**Application Reference: 2025/0207**

**Site Address: 36 Knowle Road, Worsbrough Dale, Barnsley, S70 4AW**

This application seeks full planning permission for the demolition of existing extension and the erection of a two-storey side extension.

Drawing Number: 2185/TP/006

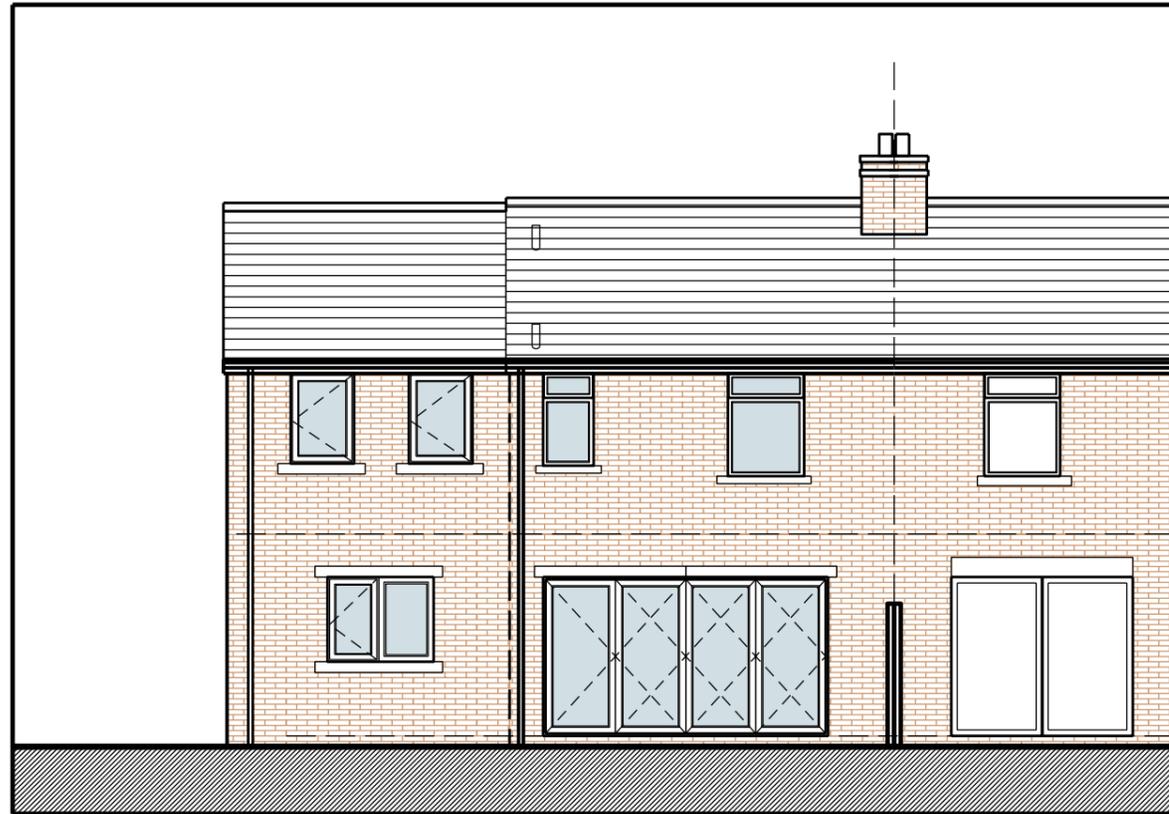
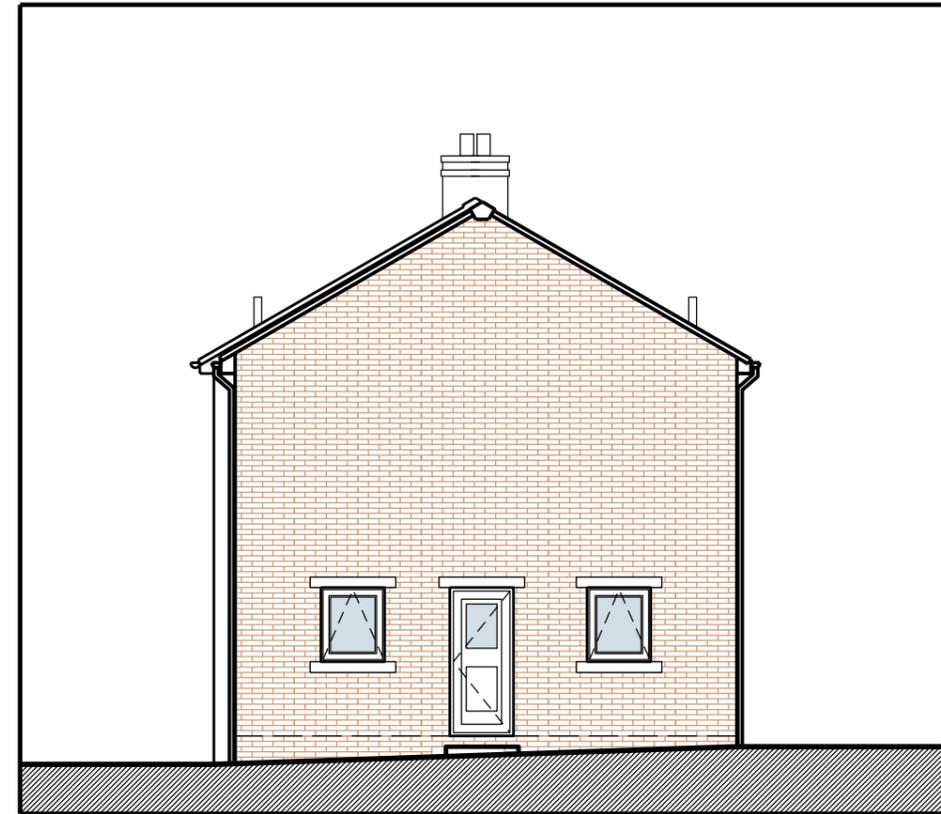
The proposed extension is to project 4m from the western side elevation of the dwelling; the original dwelling has a width of 5.5m, the maximum width allowed under the SPD would be 3.6m. Therefore the sideways projection of the proposed extension fails to comply with the guidance set out in the SPD.

The document also states that two-storey side extensions should have a set back from the front elevation by at least 500mm, to allow for a vertical break in the roof plane, a lowering of the ridge line and to reduce the terracing effect. The set back also lessens the unsightly bonding of old and new materials.

However, in this instance the sideways projection of 4m, and the set back of 300mm are considered acceptable given that the sideways projection is only 400mm above the limitations of the SPD, that a set back at the front elevation is provided, the dwelling benefits from a large side garden, the dwelling is located at a bend in the road and the extension

ensures that original dwelling remains the dominant feature and would not lead to a terracing effect.

The extension has been designed to harmonise with the original dwelling in terms of the construction materials which match the original dwelling and the layout and size of the windows located within it. It is therefore considered that the proposed extension is acceptable in terms of visual amenity and in compliance with Local Plan policy D1: High Quality Design and Place Making and as such carries significant weight in favour of the application.

Drawing Number: 2185/TP/005

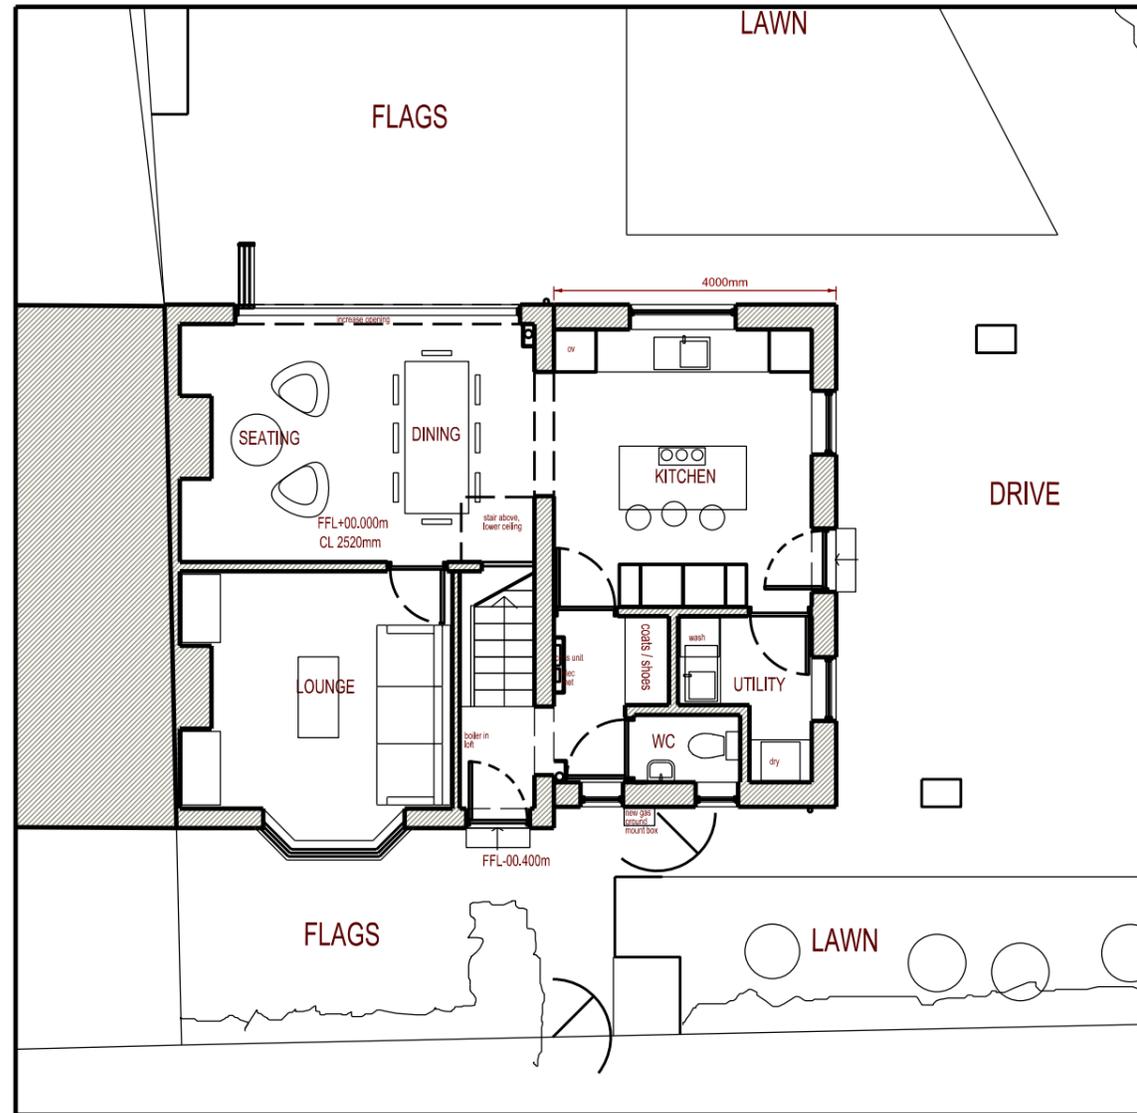
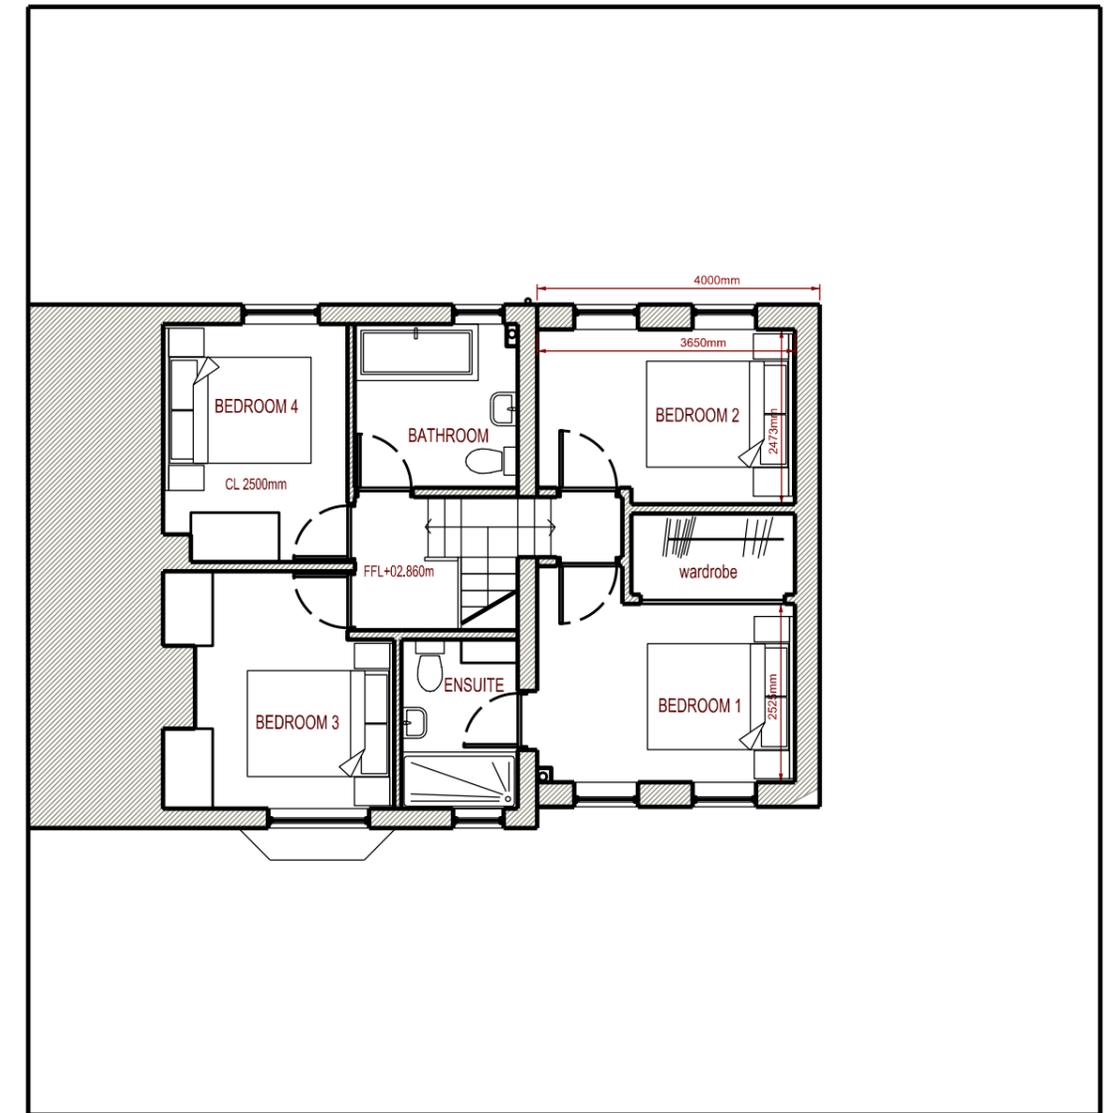
Whilst there are new windows located in the front and rear elevations the existing separation distances are maintained as the proposed extension does not project beyond the front and rear elevations. There are no windows proposed on the side elevation at first floor level and those proposed at ground floor are located a sufficient distance from the respective boundary that they would not increase levels of overlooking with the boundary treatment providing adequate screening, and as such the proposed extension would not lead to an increase in overlooking, the neighbouring properties.
